**Consultation Response from KC,
Lead Local Flood Authority**

2023/90348 Former Hillhouse Bowling Club, King Cliff Road, Birkby, Huddersfield, HD2 2RR

Erection of community sports complex (within a Conservation Area)

Date Responded: 22/05/2023.

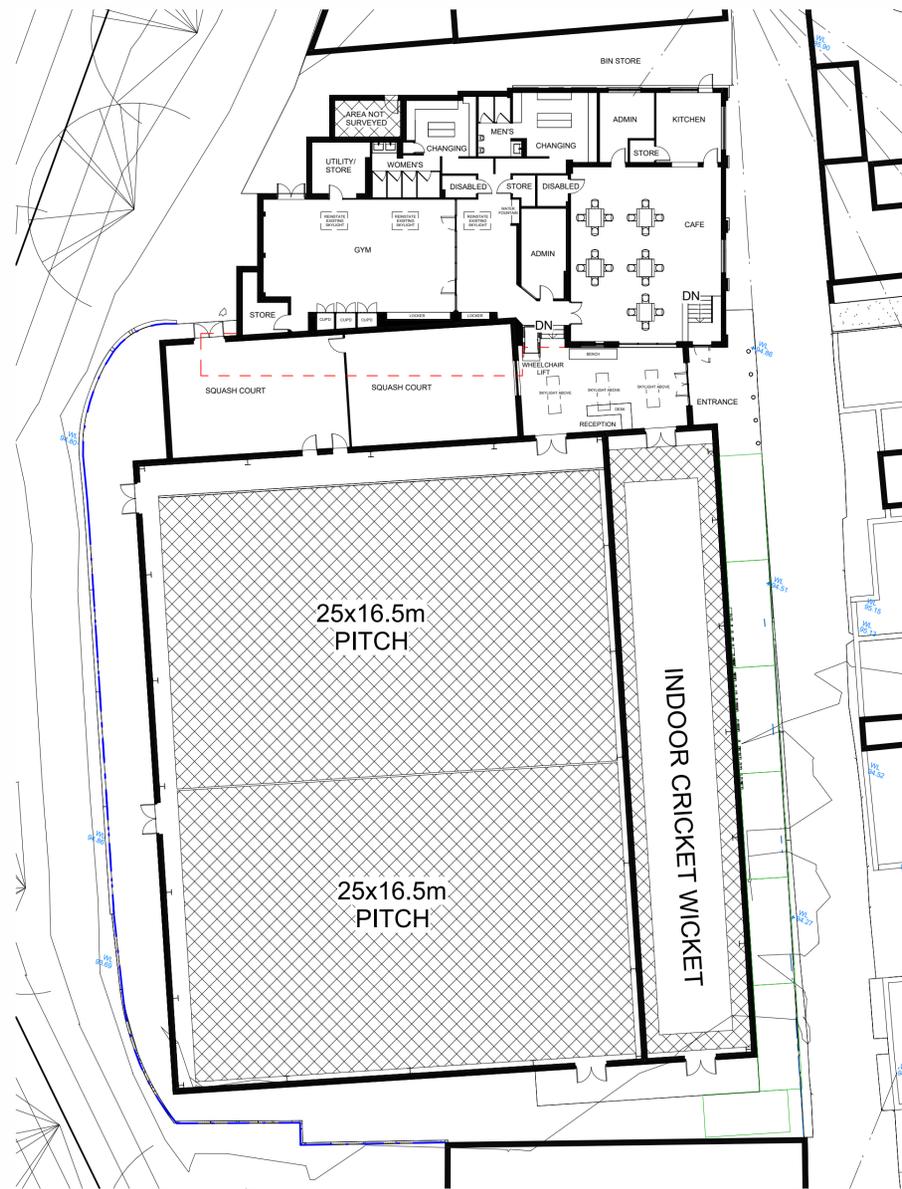
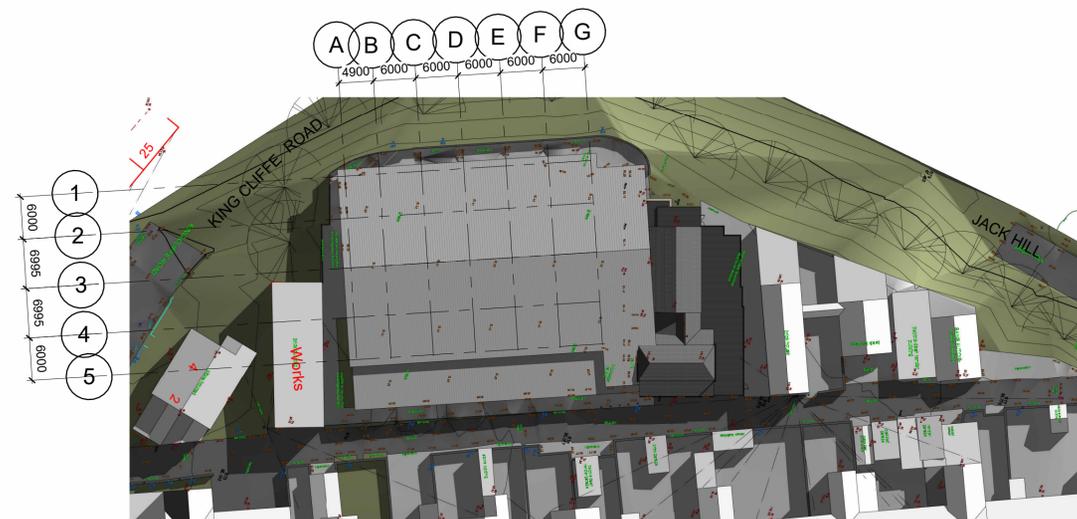
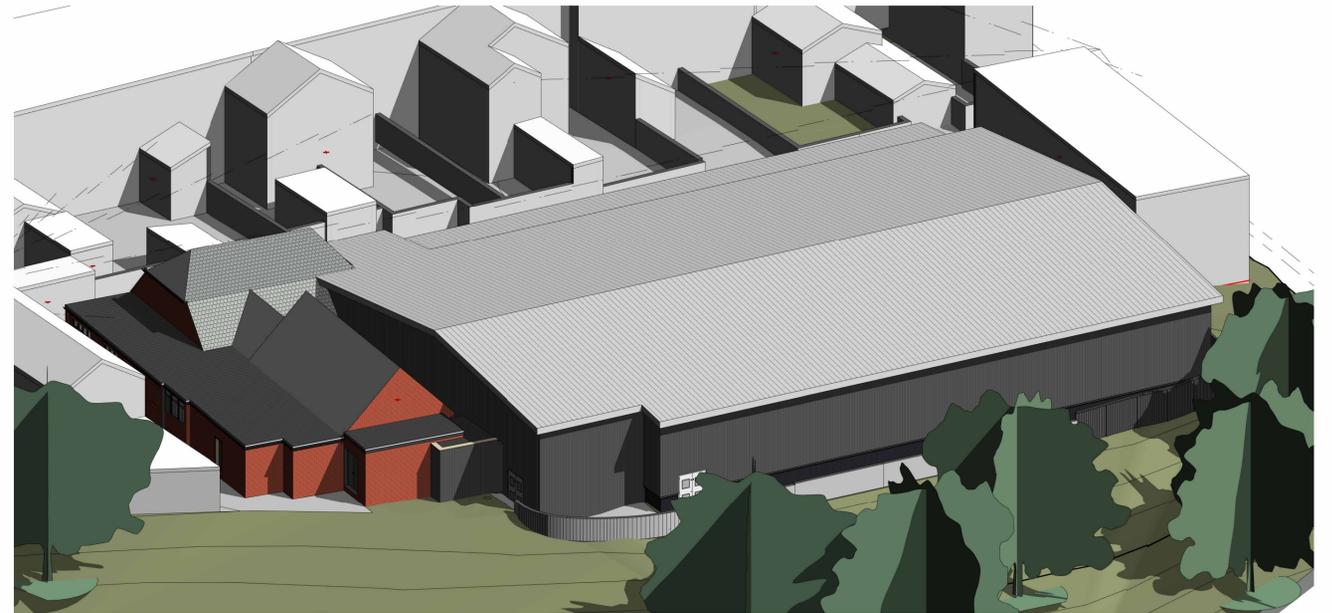
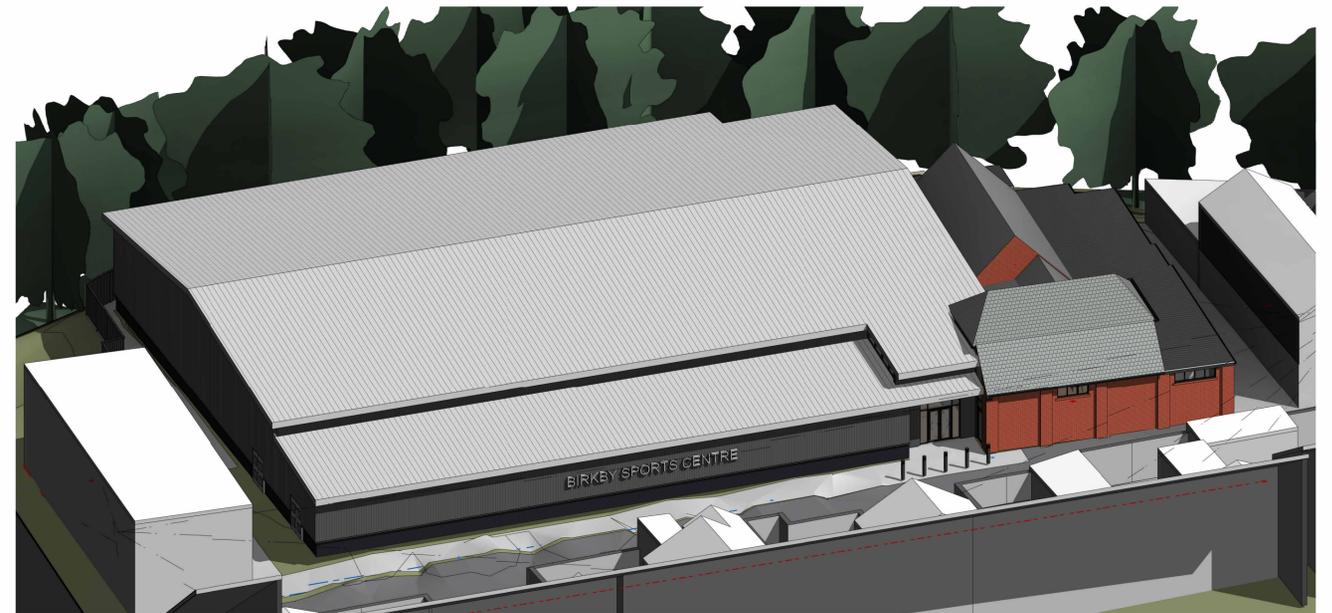
The proposed development is sited above a steep slope down to Jack Bridge therefore infiltration into the ground will not be feasible due to the risk of re-emergence further down the slope.

The existing retained building can continue to drain surface water as at present, however the surface water drainage from the new roof area located over the former bowling green will be limited to greenfield run-off rate (5 l/s per ha) subject to a minimum flow control outlet diameter of 75mm.

There does not appear to be any space available within the site to accommodate attenuation storage, therefore the developer should provide details of how the attenuation storage is to be provided.

In addition, Hydraulic Calculations based on the allowable surface water discharge rate detailed above should be provided to confirm the attenuation storage volume is sufficient to contain the 1 in 100 year rainfall event (plus climate change allowance) without flooding off-site.

The routing of floodwater during an exceedance event should also be provided. This should indicate that no existing properties are at increased risk of flooding within their curtilages.

1. Surface water drainage design.
2. Location and details of the Attenuation Storage including access points for maintenance.
3. Flood routing.
